Engineers Comments Regarding Surface Water Drainage

Application Reference:	AL/20/26/PL	Reviewer Reference:	ADC/EXT5/AF
Planning Officer:	Simon Davis	Date of Review:	15/07/2026
Site Name:	Land at West Barn Old Dairy Lane Norton PO20 3AF		
Application Description:	Demolition of existing tennis court and erection of a commercial building (within Use Class E(g), parking, landscaping and other associated works (resubmission following AL/107/25/PL). This application is a Departure from the Development Plan, may affect the character and appearance of the Norton Lane, Norton Conservation Area and is in CIL Zone 3 (Zero Rated) as other development.		
Assessment Number:	4

**PROPOSED DRAINAGE LAYOUT**  
SHEET 1 of 2

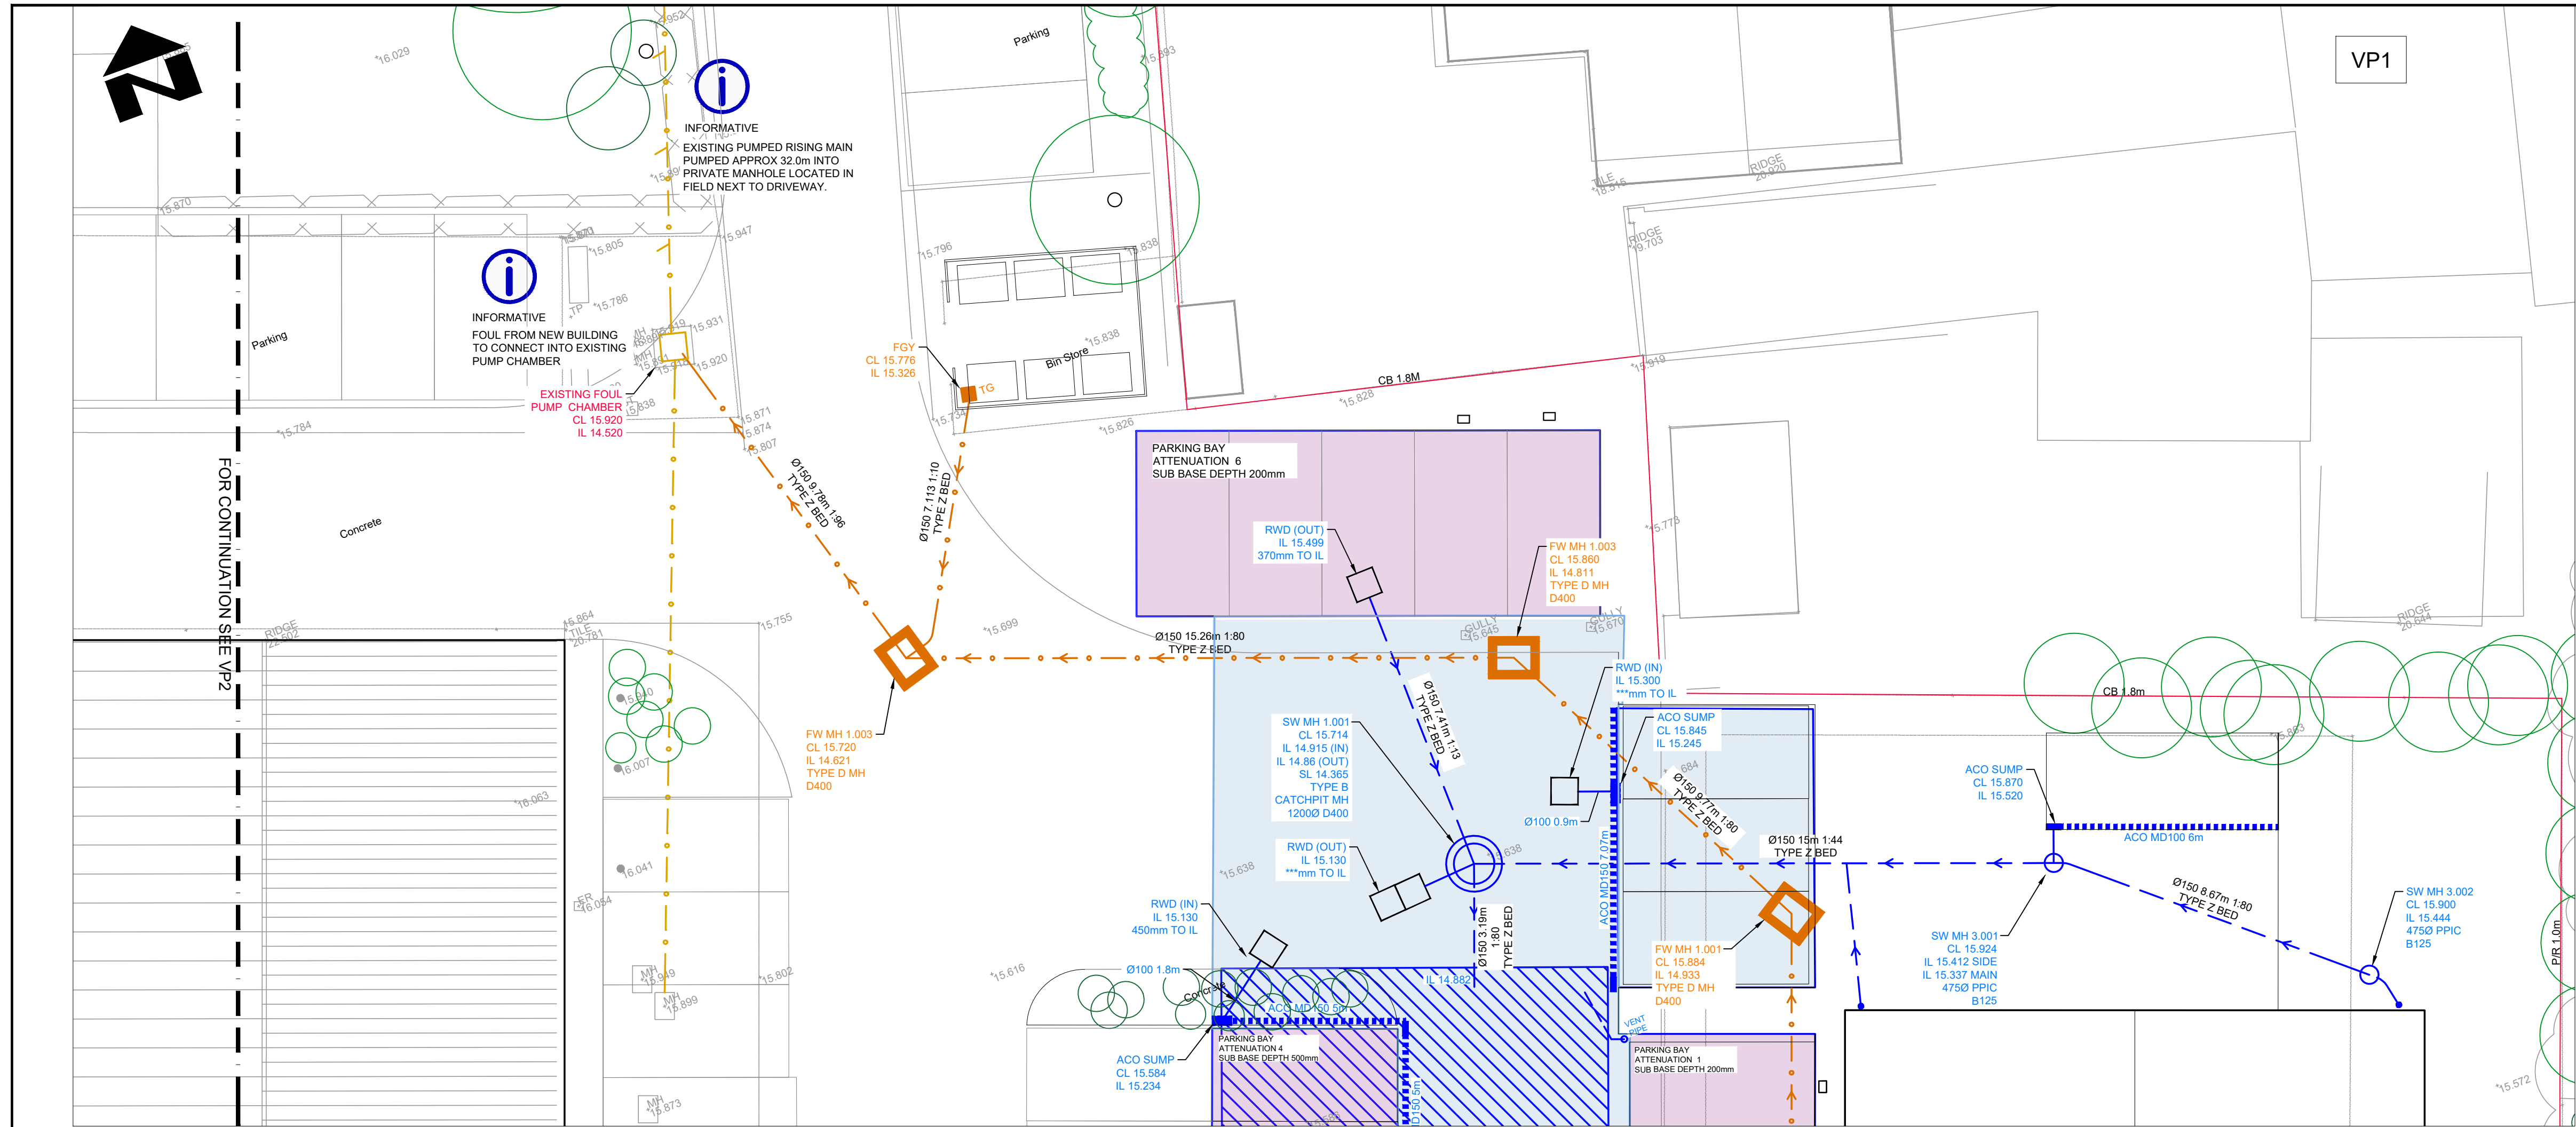
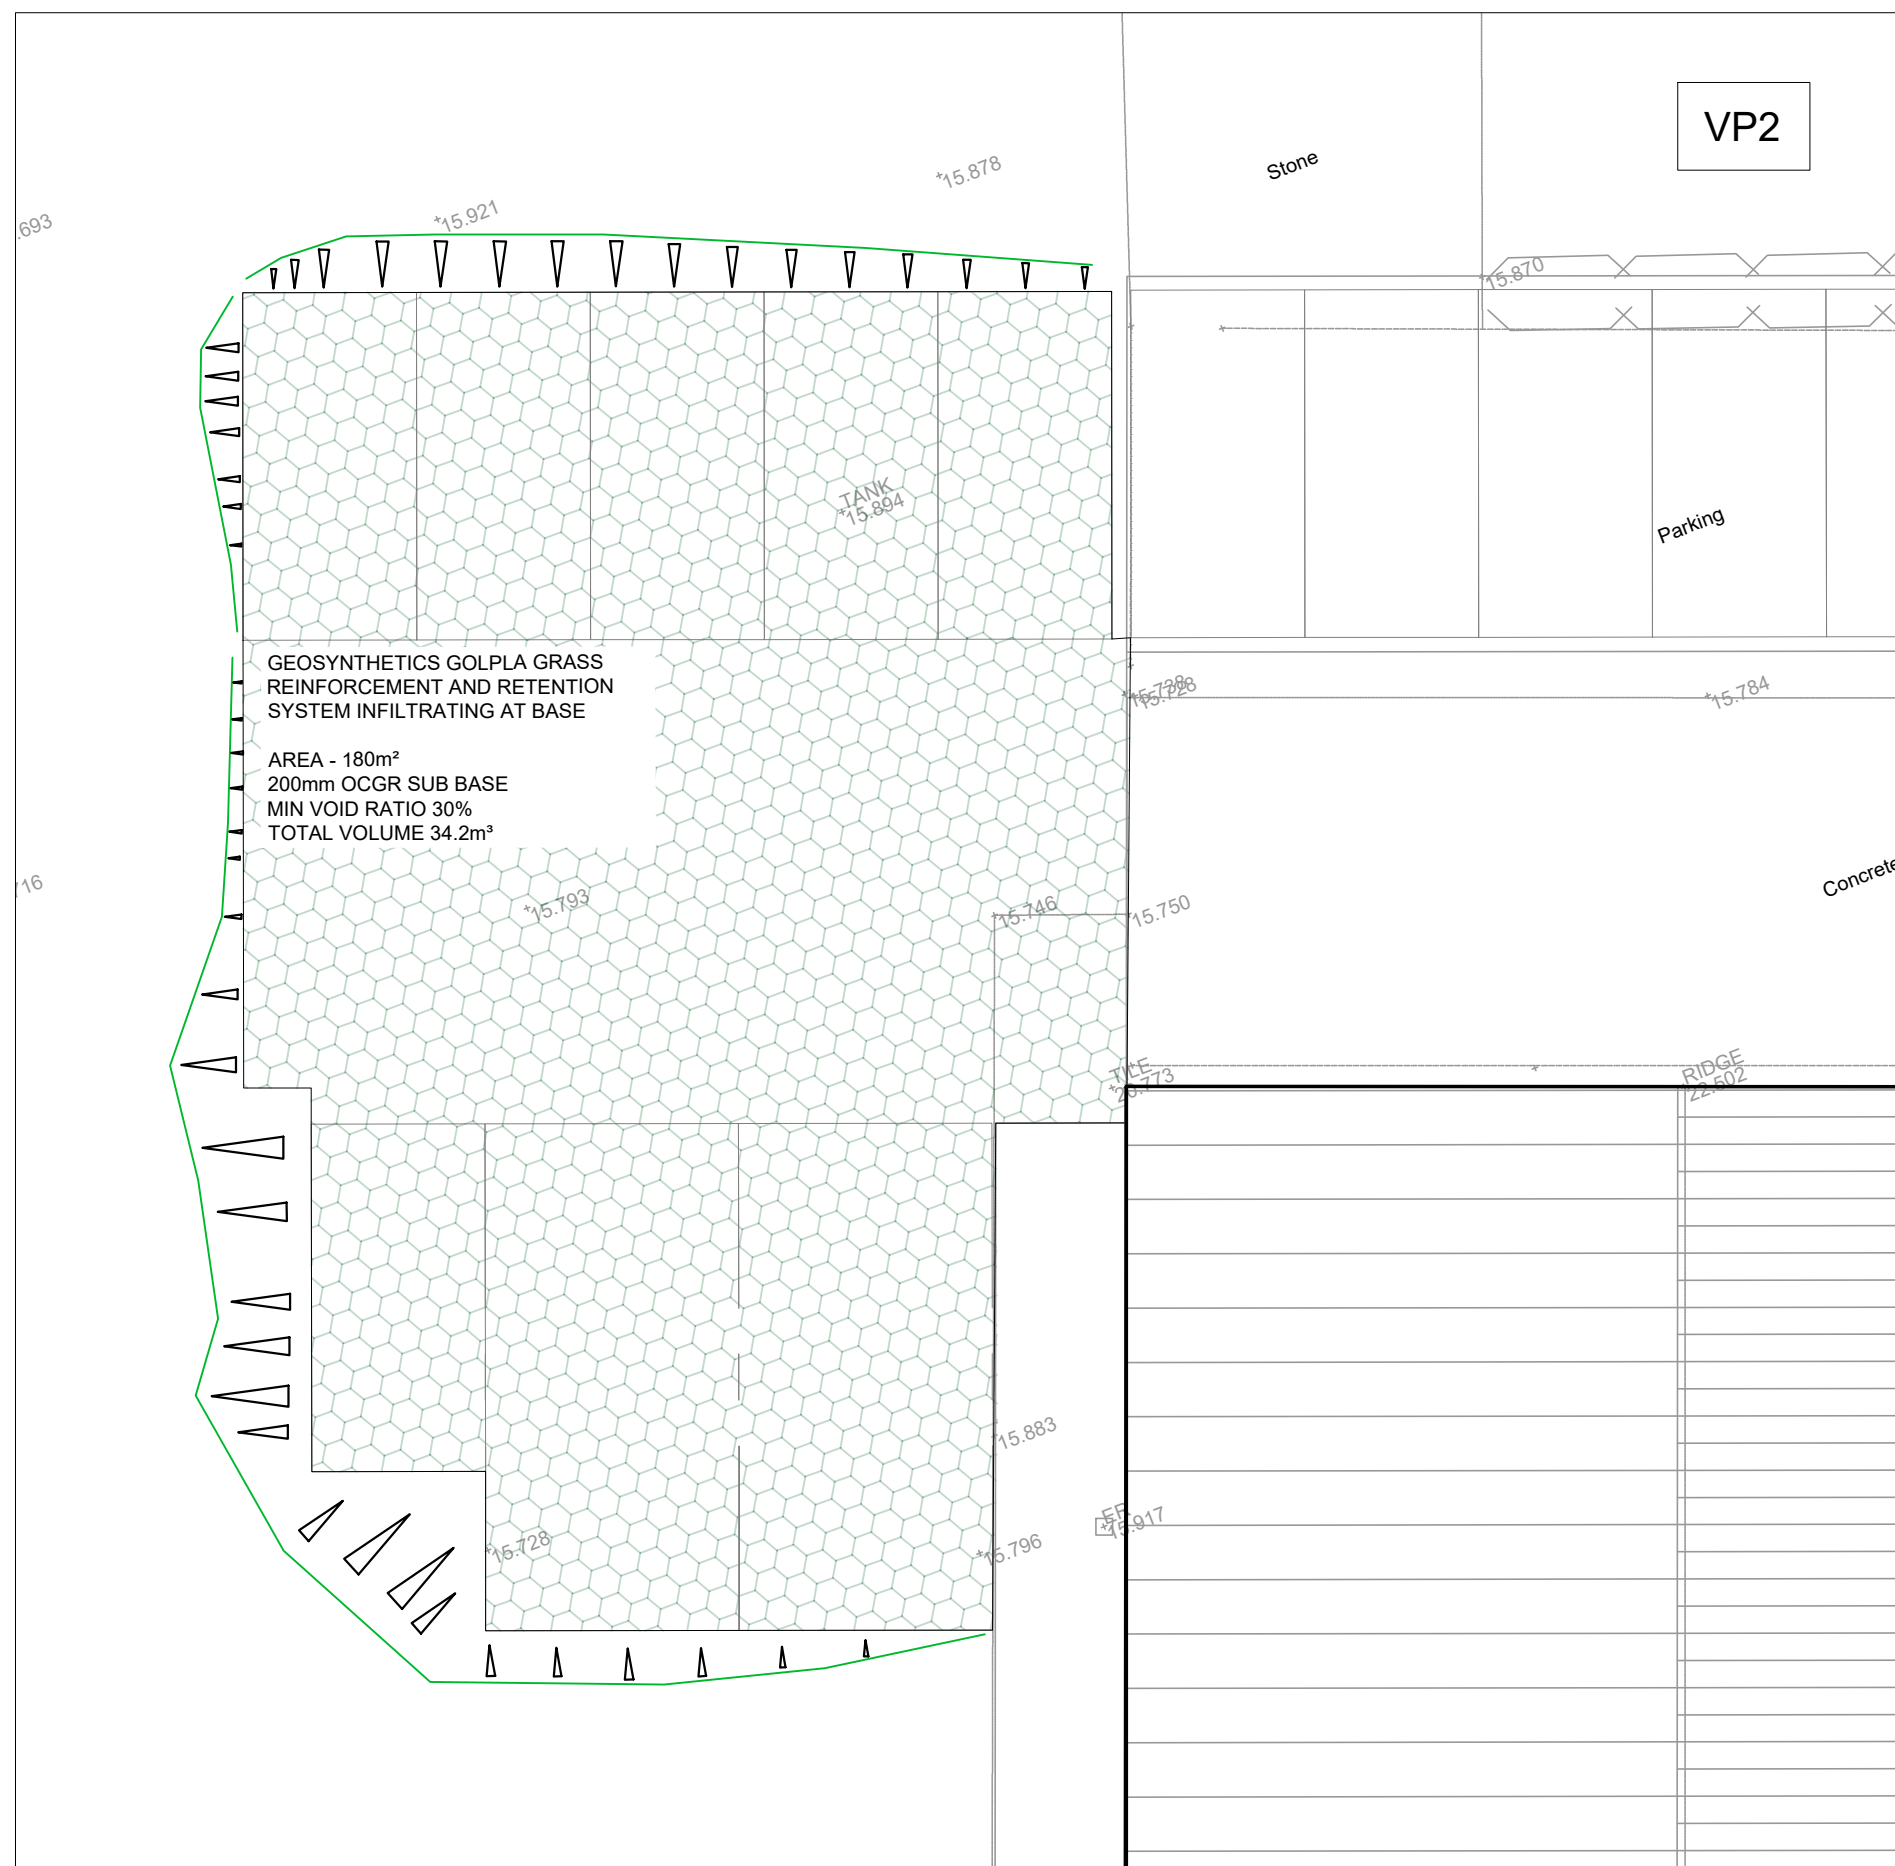
- 1.4. The proposed soakaway has been adjusted to be larger in plan and less deep to mitigate the risk of high ground water. The highest groundwater level for the current data is 2.2m below ground level. The proposed soakaway is approximately 0.8-0.9m below existing ground levels. The base therefore has a margin of buffer before the 1m vertical offset which is acceptable on a precautionary basis to mitigate the possibility that the annual peak had not been fully reached at the end of the groundwater monitoring.

- 3.2. Revised drainage calculations dated 10.06.2026 have now been provided with the with the updated soakaway design and factor of safety. There is a small discrepancy in that the base level of the soakaway on the drainage layout plan is 14.772 whereas the base of soakaway (IL) in the calculations is 14.820 (48mm higher) but in terms of analysis the higher level in the calculations is robust.

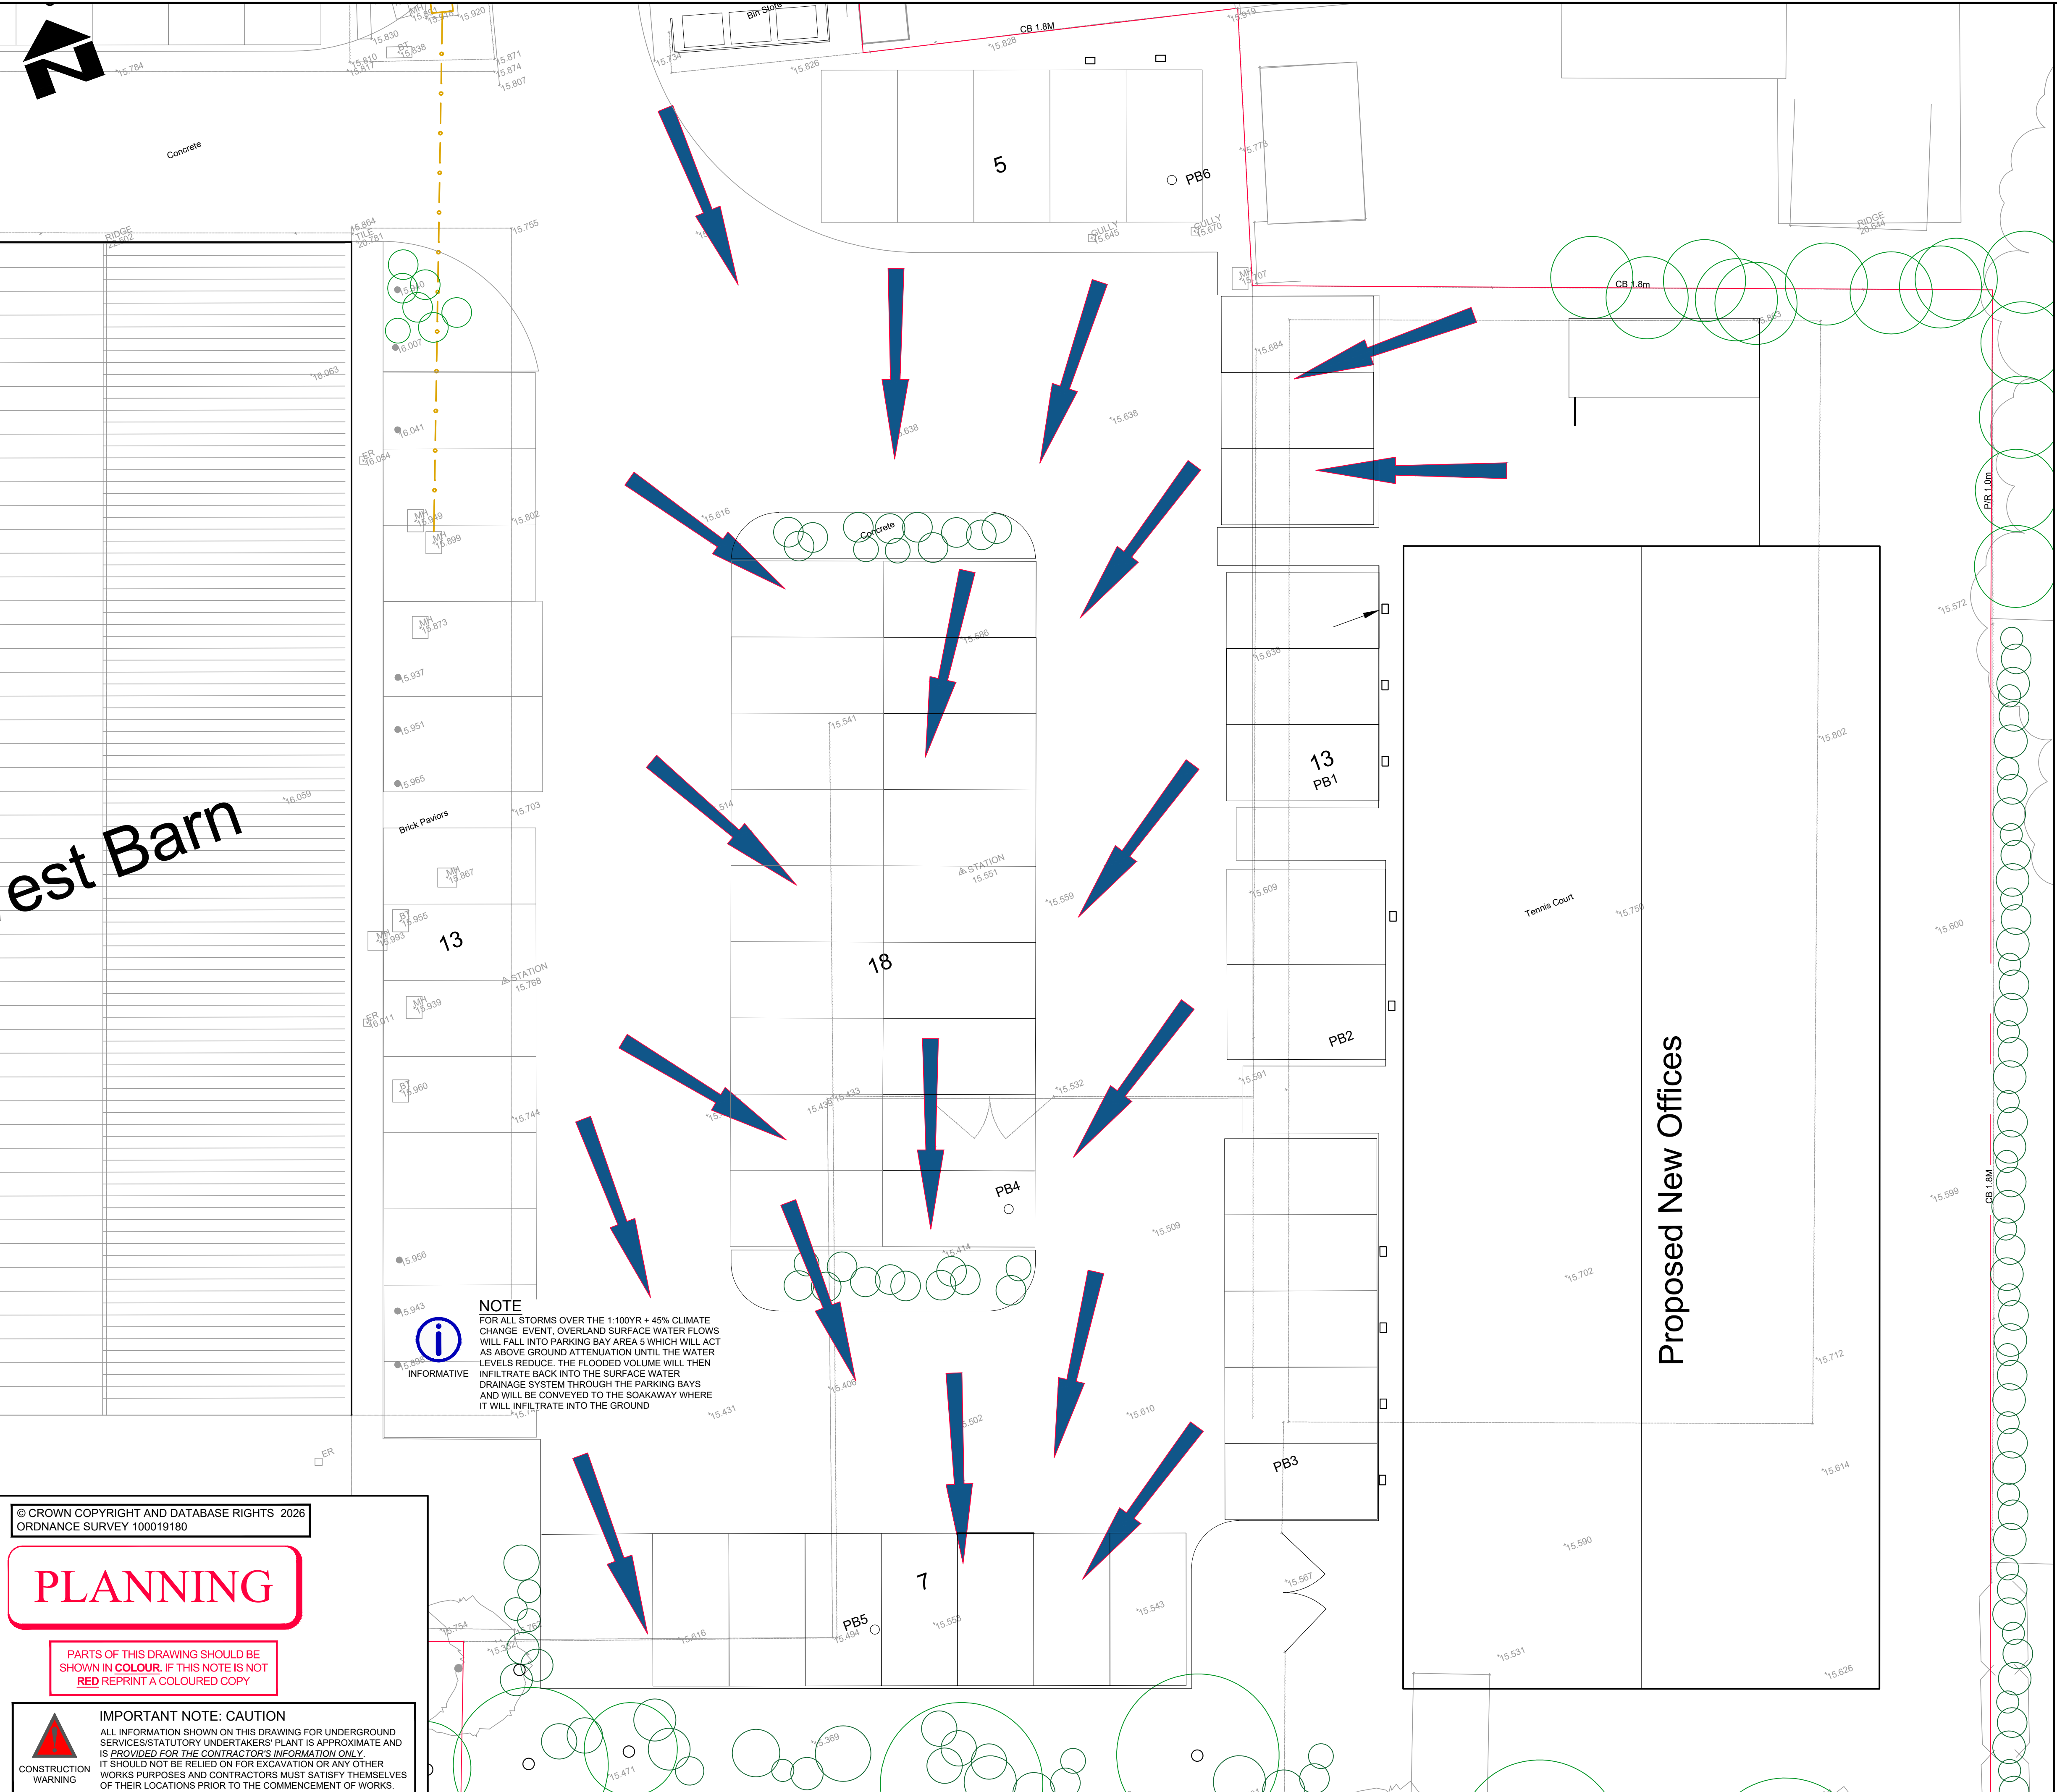
- 3.1. An impermeable areas plan is now provided. There are some areas of hard paving omitted between the parking bays and adjacent to the building which do not appear to be soft landscaping on the submitted landscape architecture layout. However, these areas are a relatively small proportion and are balanced by the additional allowance of 350 square metres added to the model as set out in the drawing note.

Chart 1 – Groundwater Records

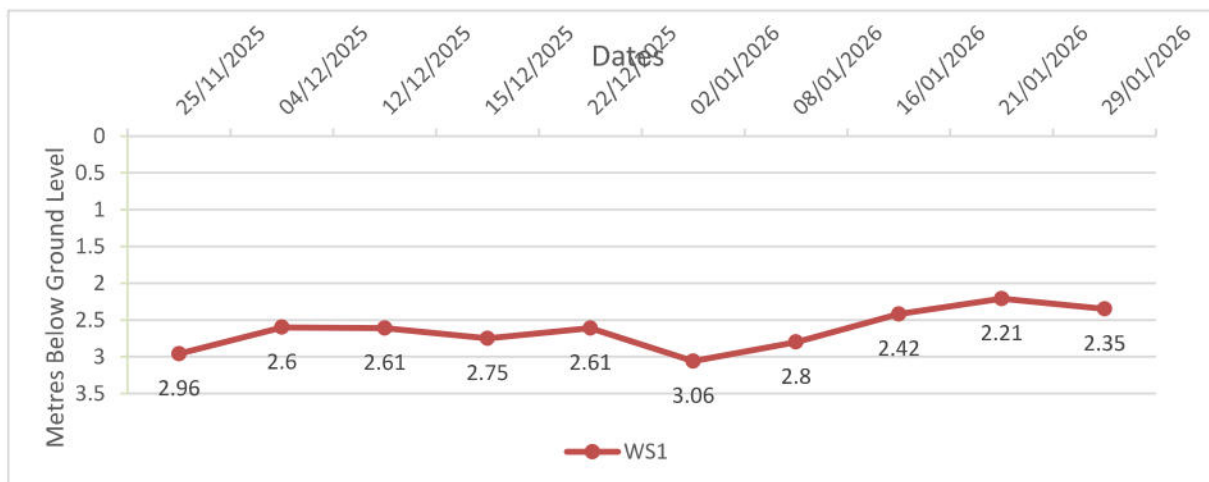
- 1.3. A ground investigation has been provided which includes winter groundwater monitoring up to the end of January 2026 and it is stated in the ground investigation report that groundwater levels are increasing up to a likely seasonal maximum in March. The current scope of the groundwater monitoring was previously agreed with ADC as part of pre-application enquiry.
